From: Marsha Kearney <rmeek1978@gmail.com>
Sent: Monday, August 03, 2020 9:02 PM
To: Richard Stevenson
Cc: p crump; Ron Bohannon; rick@rba81.com; gnh5976@gmail.com; 1garciagang@gmail.com; mdmiraba@msn.com; meganfitz@live.com; bcreel@msn.com; frandimarco@msn.com; cfmirabal@gmail.com; ruffkat@yahoo.com; david.m.lopez@msn.com; garnand_lu@yahoo.com; kmcvey124@comcast.net; tjmurieta@msn.com; nenaperkin@gmail.com; avalgman12@gmail.com; scott.templeton@comcast.net; chavezdyx4@yahoo.com; mccormackdj@comcast.net; erin.coffman@yahoo.com; huerta.loretta58@gmail.com; gayle.binkley@me.com; marshakearney@gmail.com; nauticalhutch@gmail.com; miladybutler@yahoo.com; rfasel@fed.net; Gomez, Angela J.; Wolfenbarger, Jeanne; Gould, Maggie S.
Subject: Re: [#2020013] Wintergreen Apartments DRB questions (PR-2020-004030)

The intent of this email is to provide responses to the questions raised by neighbors at the DRB hearing on July 22nd 2020, in regards to the proposed Wintergreen Apartment project City project number PR-2020-004030.

SECTION 3

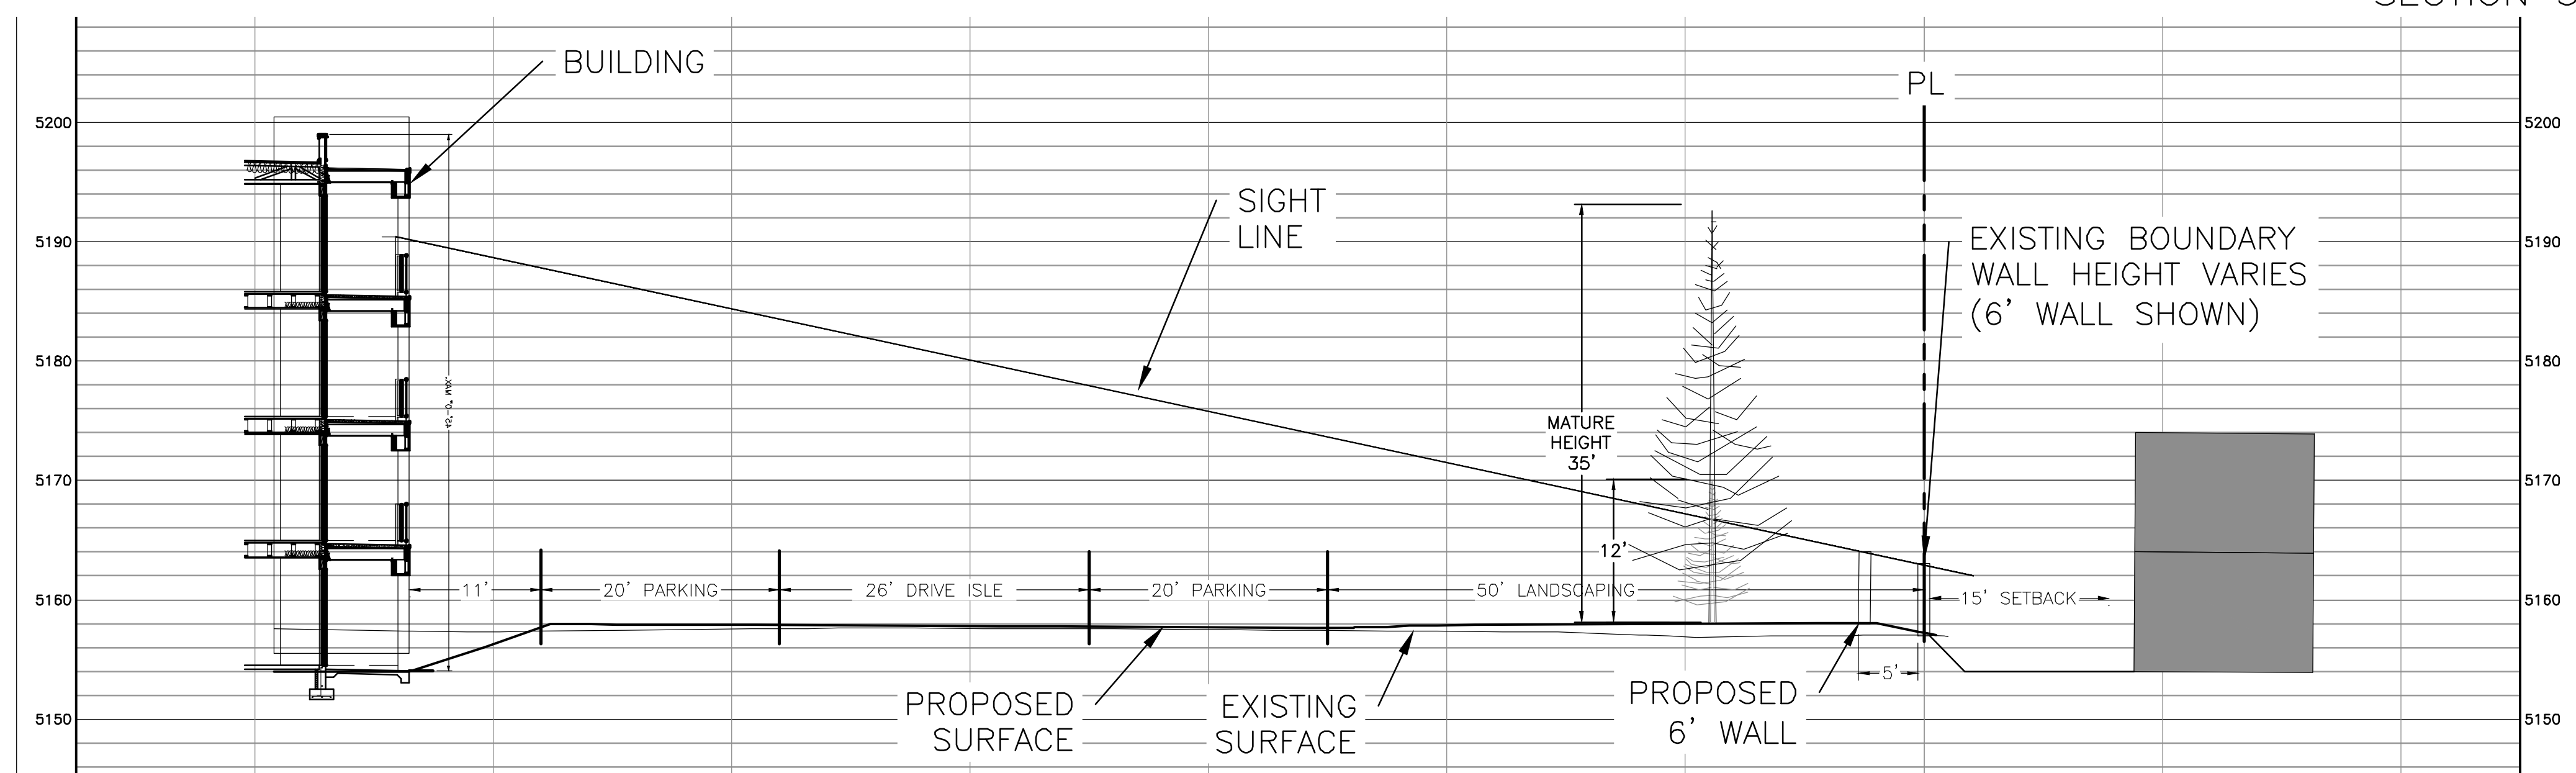
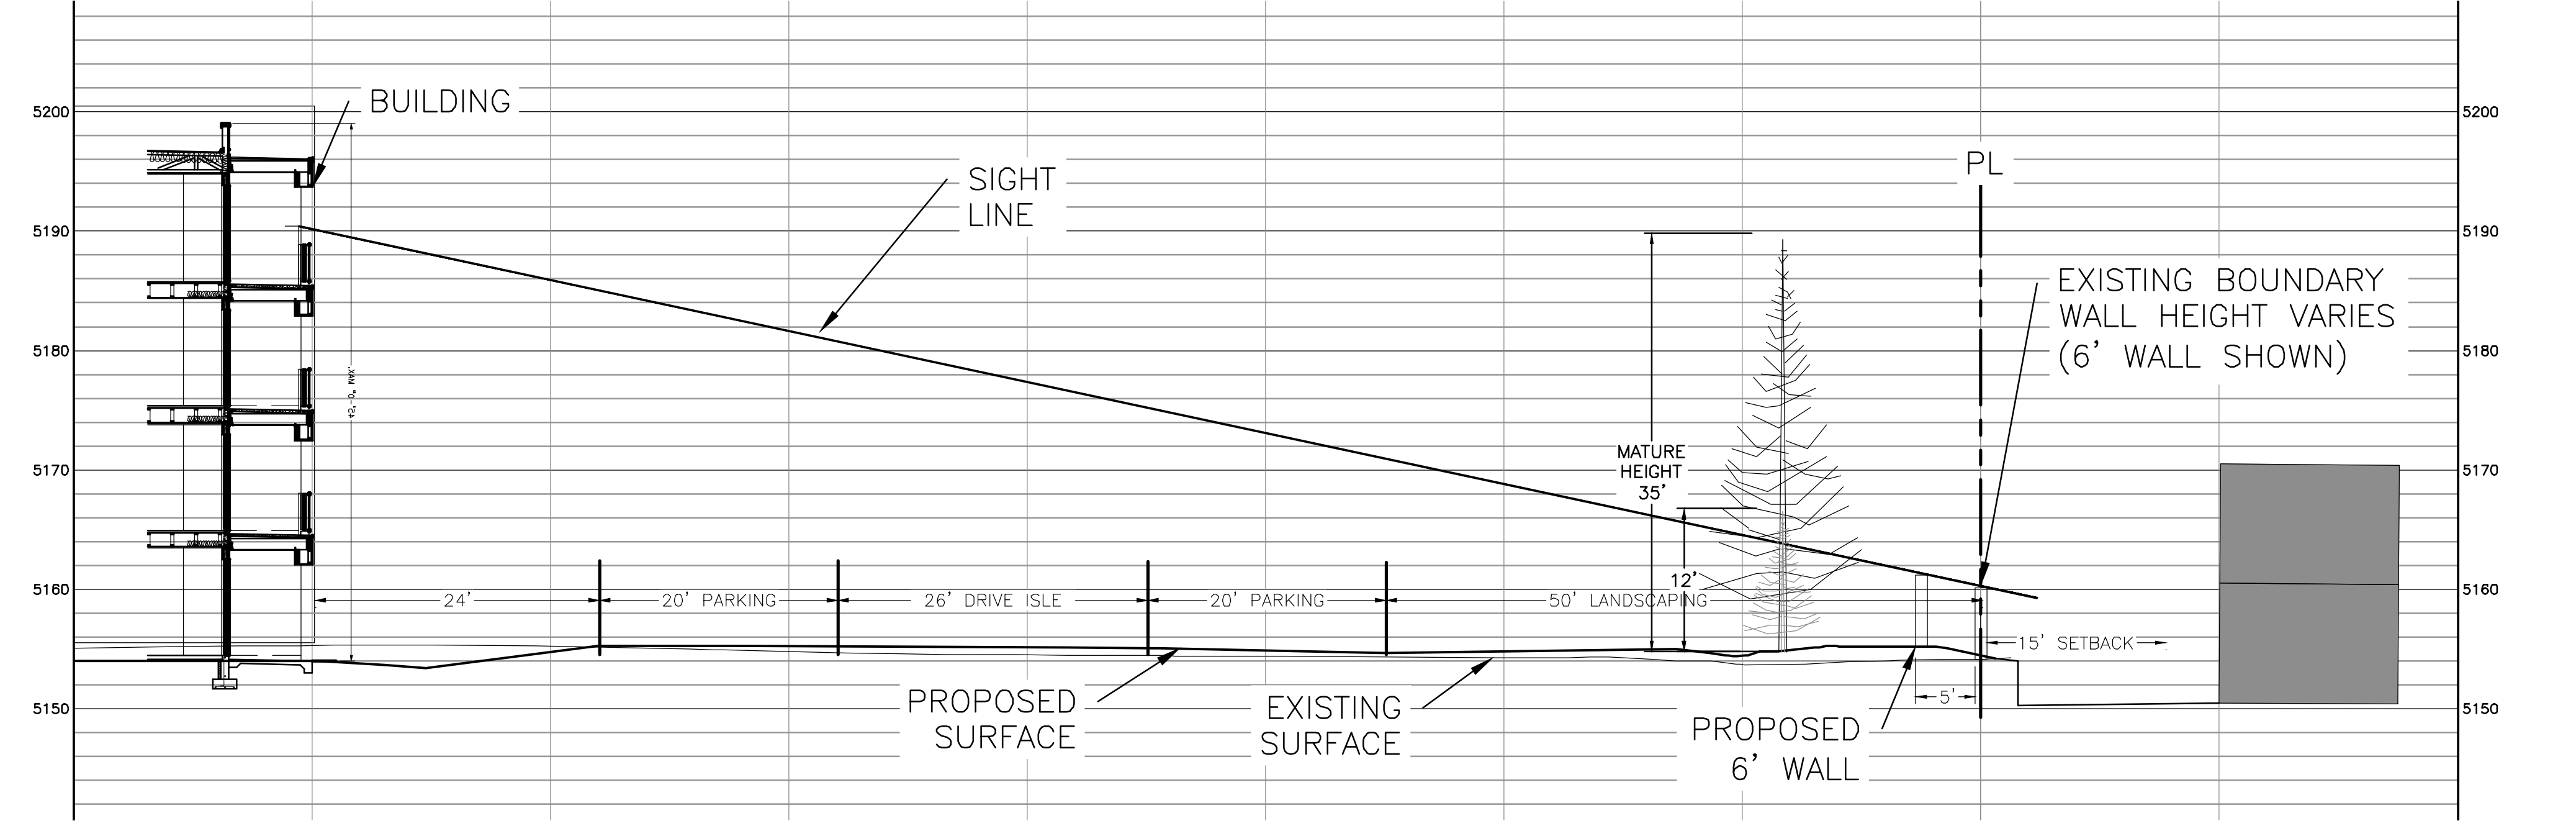
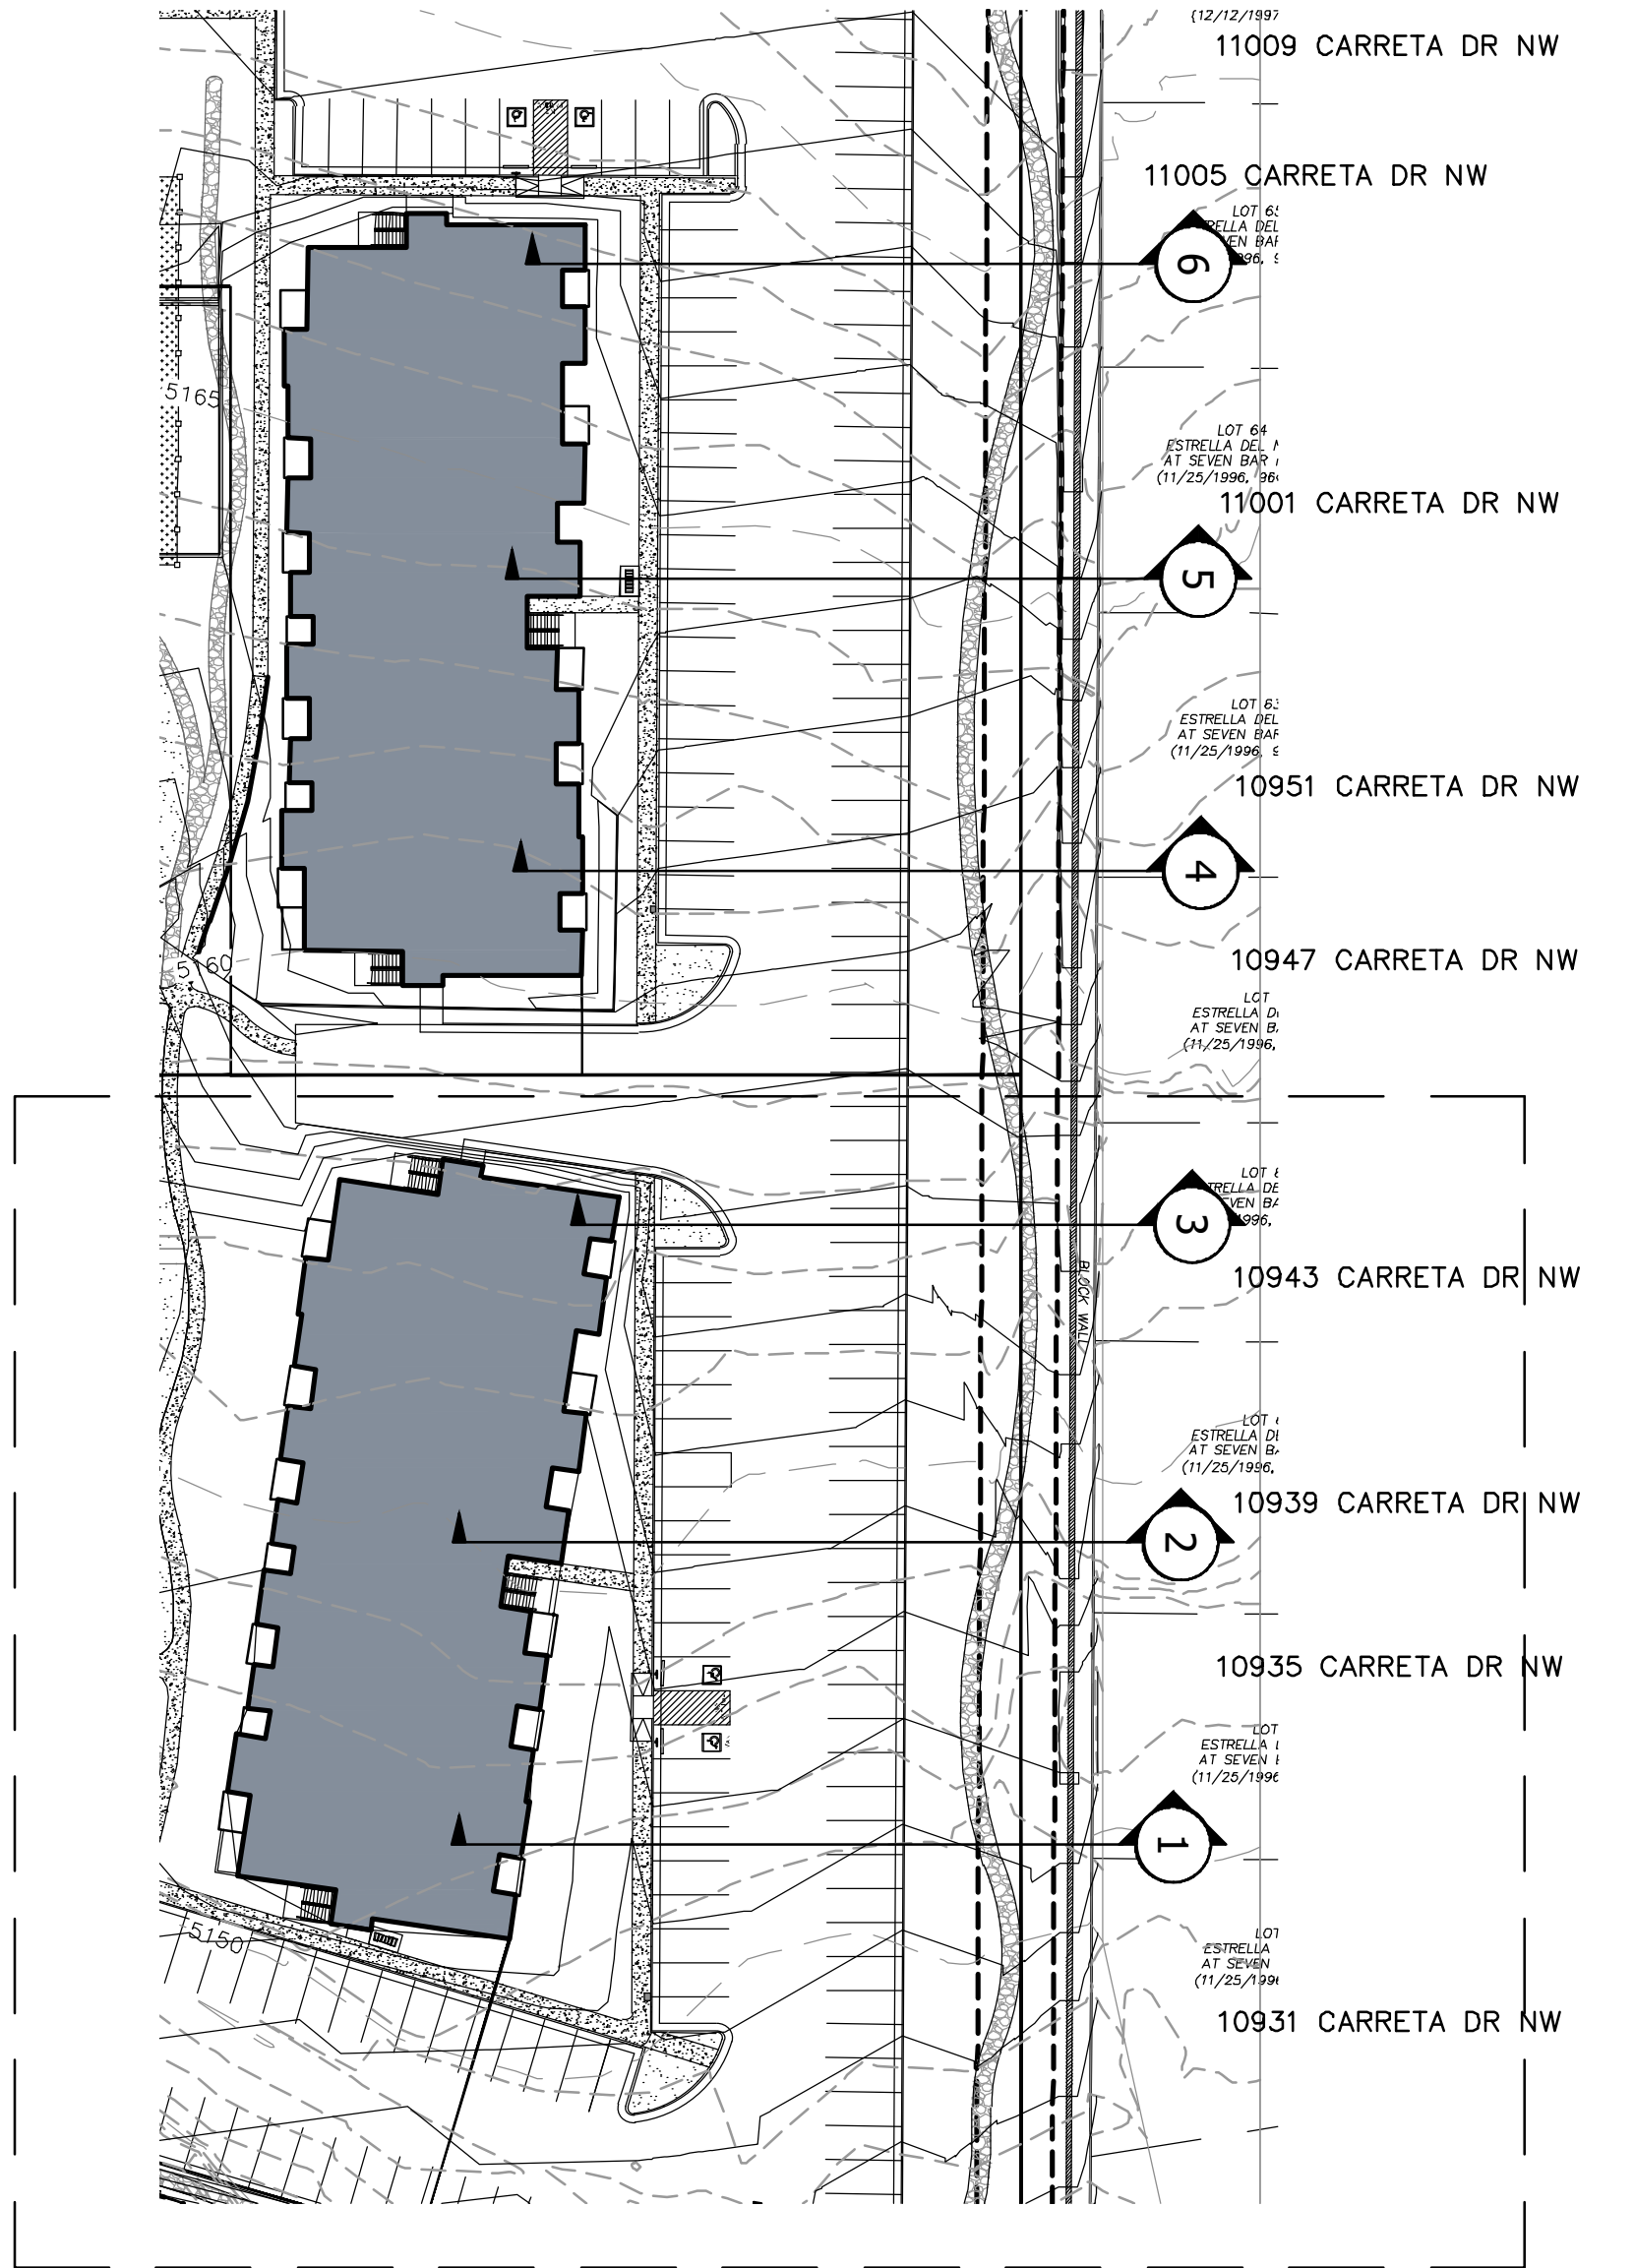
7. The cross-sections provided are inadequate when speaking to the privacy and noise barriers needed for the residents. Cross-sections show trees. Where exactly are they planted, spacing, heights, etc. We have no clear view of what will be in the buffer and how it will protect the adjacent property owners.

Response: A view plan exhibit was prepared to show the sections along the east half of the property and is attached to this email.
